Struthers Ranch Polaris Grading & Erosion Control Plans El Paso County, Colorado

STRUTHERS RANCH POLARIS
LOTS 1-2, STRUTHERS RANCH SUBDIVISION FILING NO. 4

SITE GRADING AND EROSION CONTROL PLAN

Grading & Erosion Control Plan_V2.pdf Markup Summary

11 RETAINING WALL DTL (6'-0" TO 12'-0") HIGH
SCALE: 1/2"=1'-0"

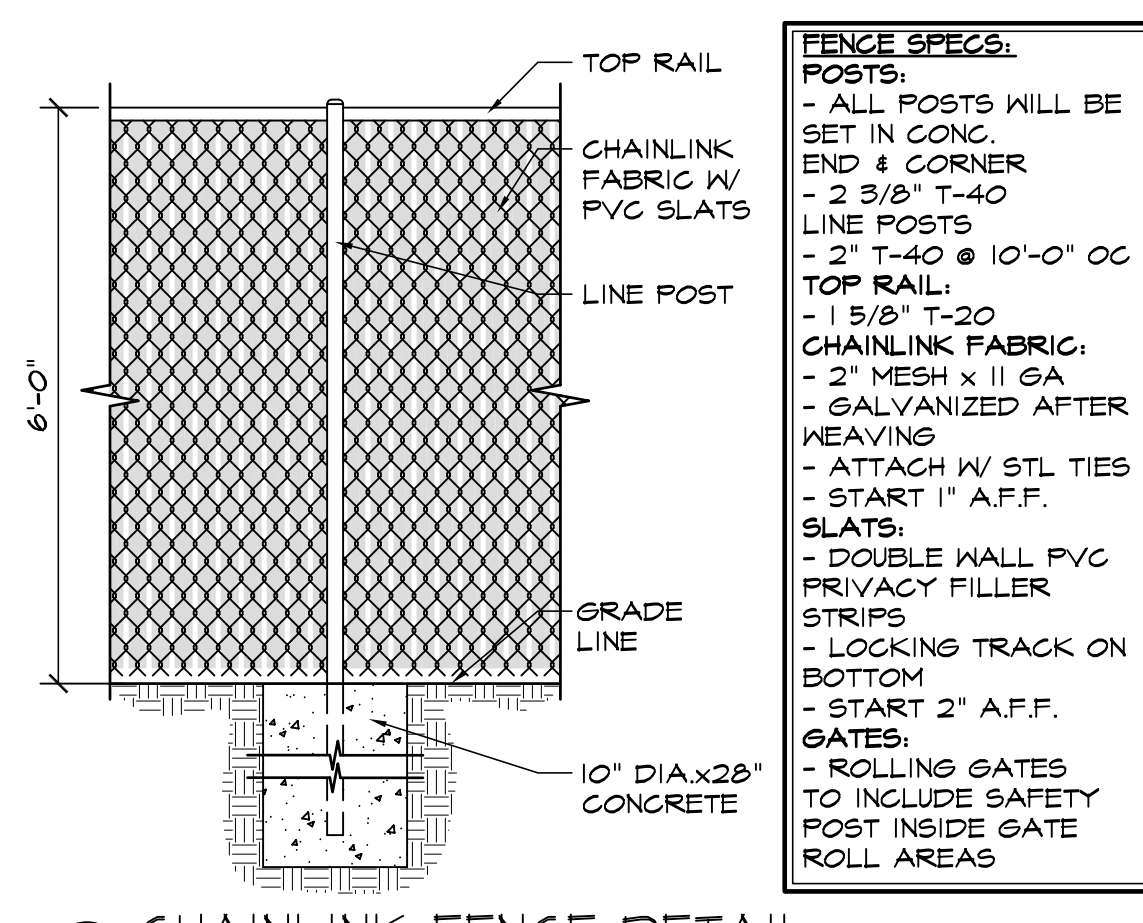
Per the grading plan the flowline on Struthers Rd at that point is 6757', which with the height of the retaining wall exceeds over the 30'. Revise retaining wall height to meet criteria by lowering by 6 inches.

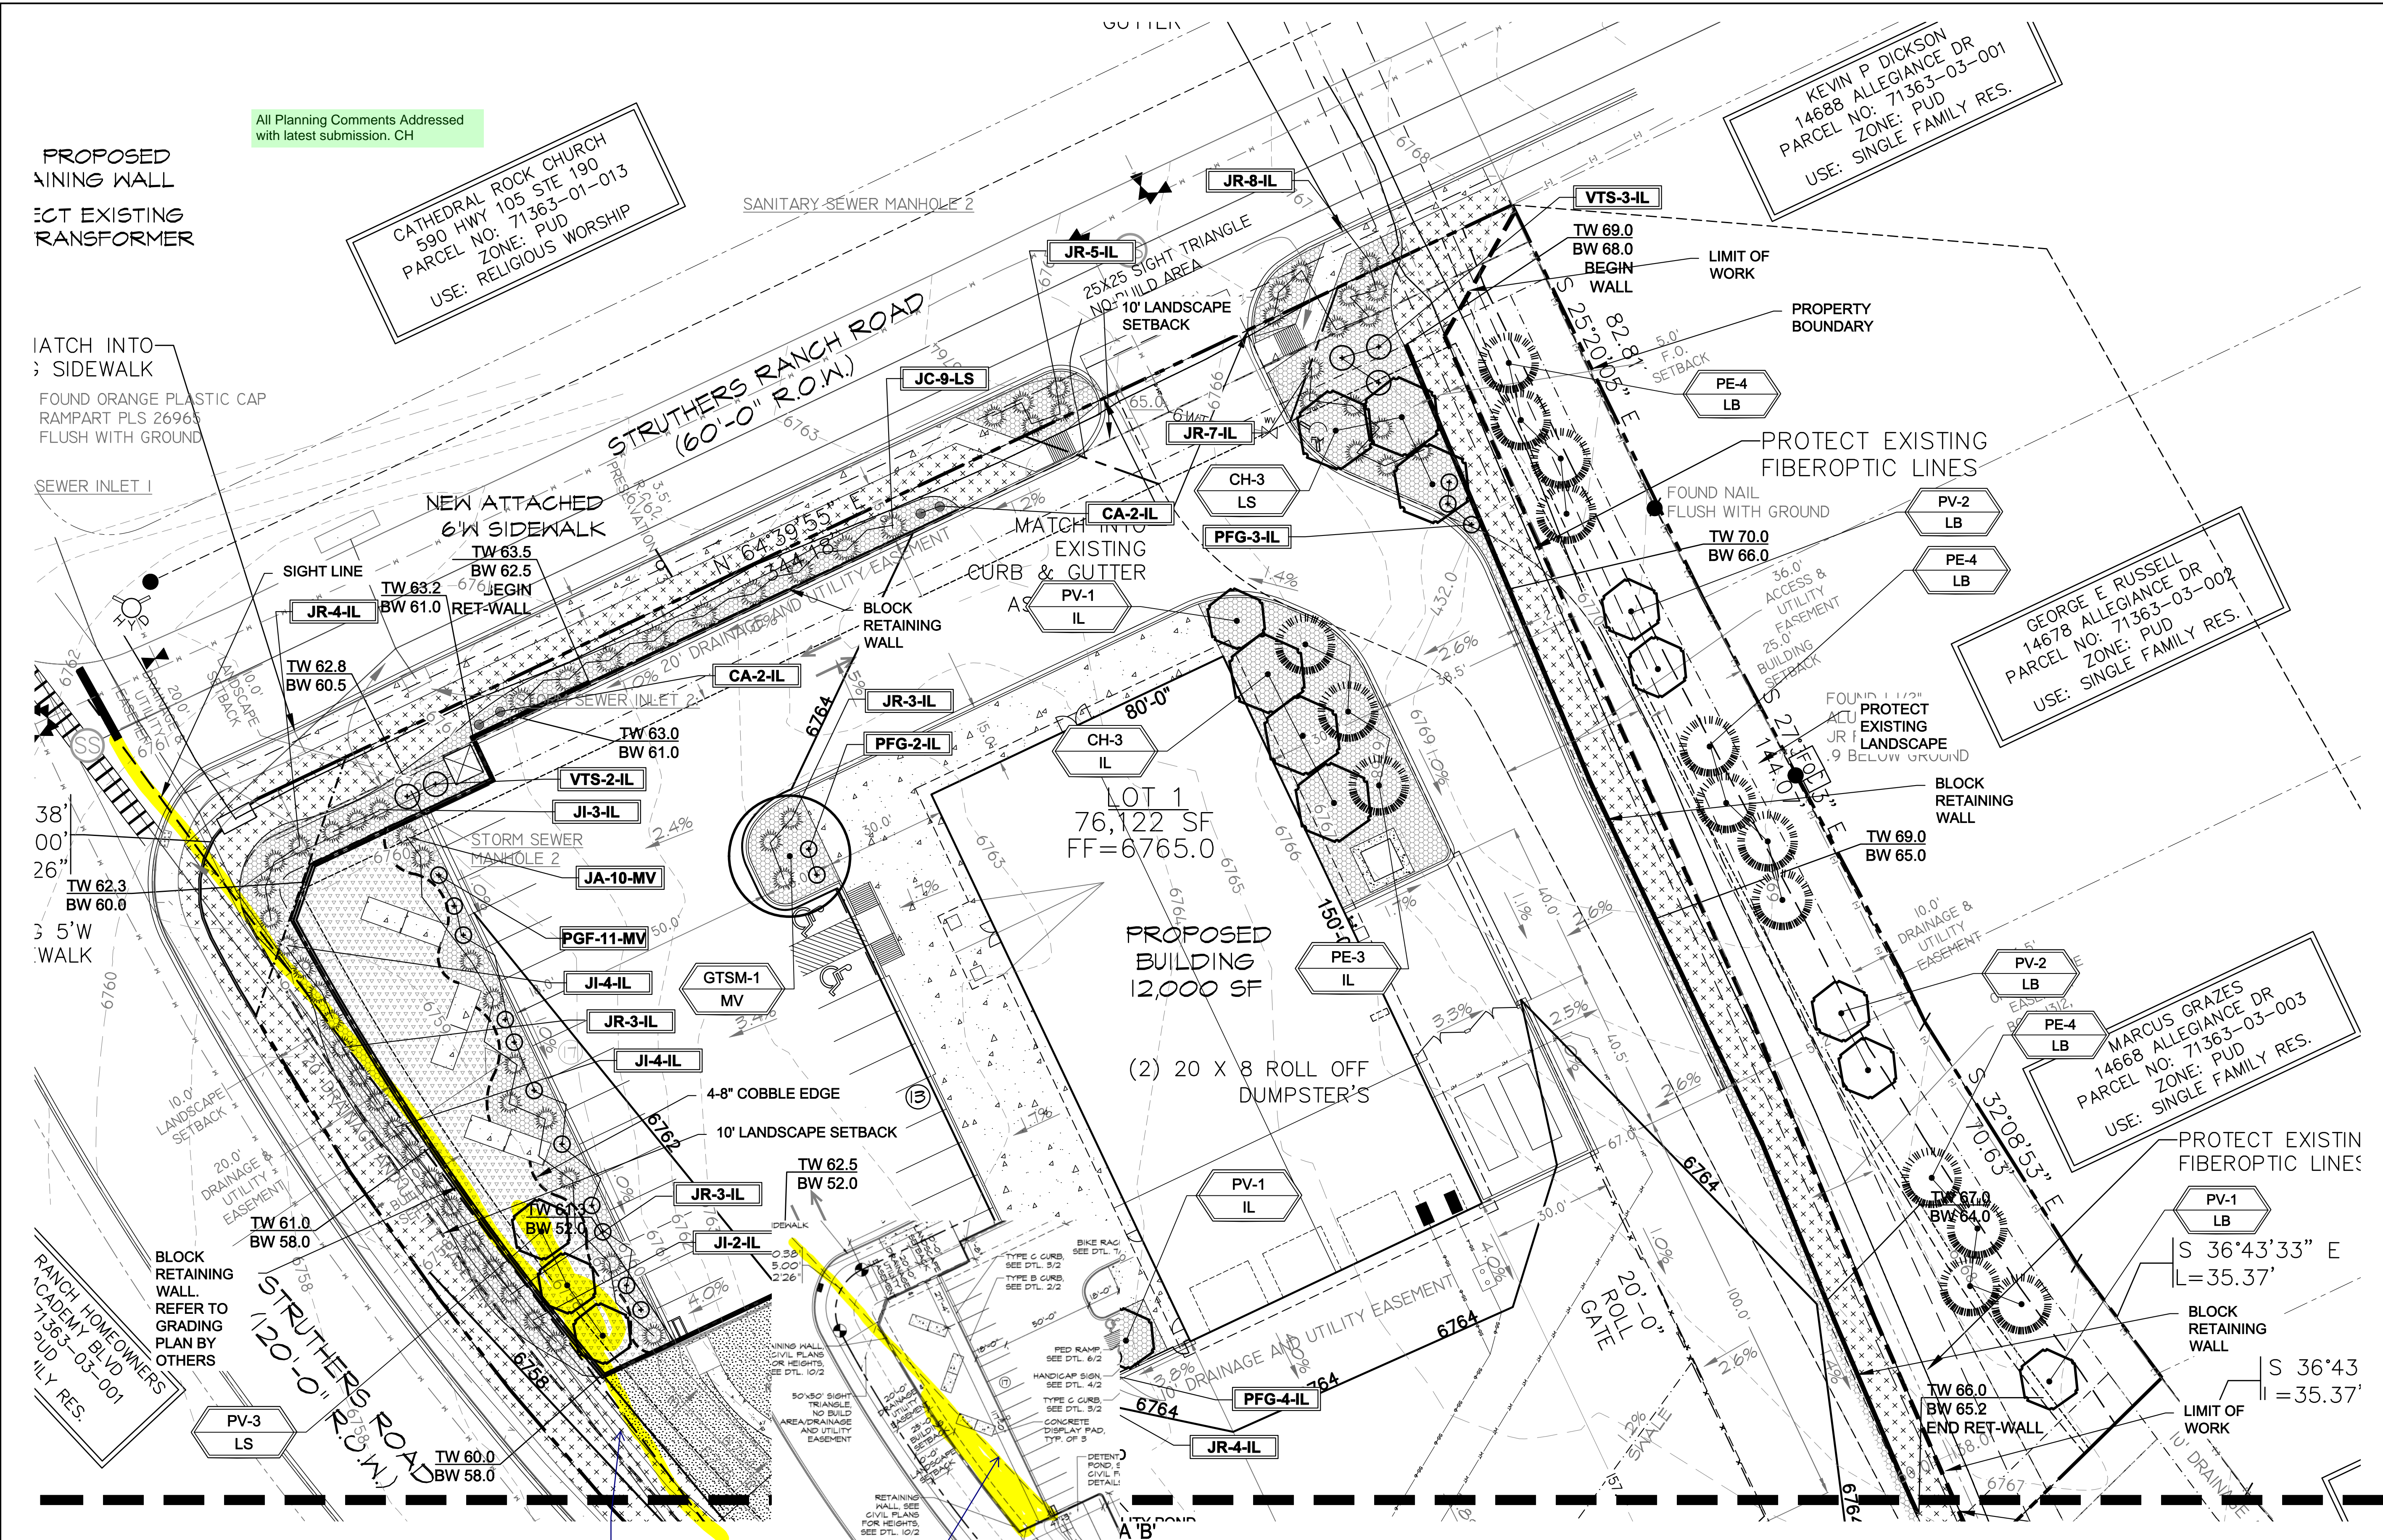
Provide a typical section cut detail on either the site plan or the grading and erosion control plan

Show the line of sight (Blue line is approximate based on Bluebeam software measurement tool. Design engineer to show actual layout and not per the review markup)

Provide a profile along the line of sight showing the existing & proposed ground, and line of sight from driver's eye to object height per criteria.

Update pipe design so it slopes towards the existing inlet.

Show the 6758 contour for the top of berm per the spillway detail.
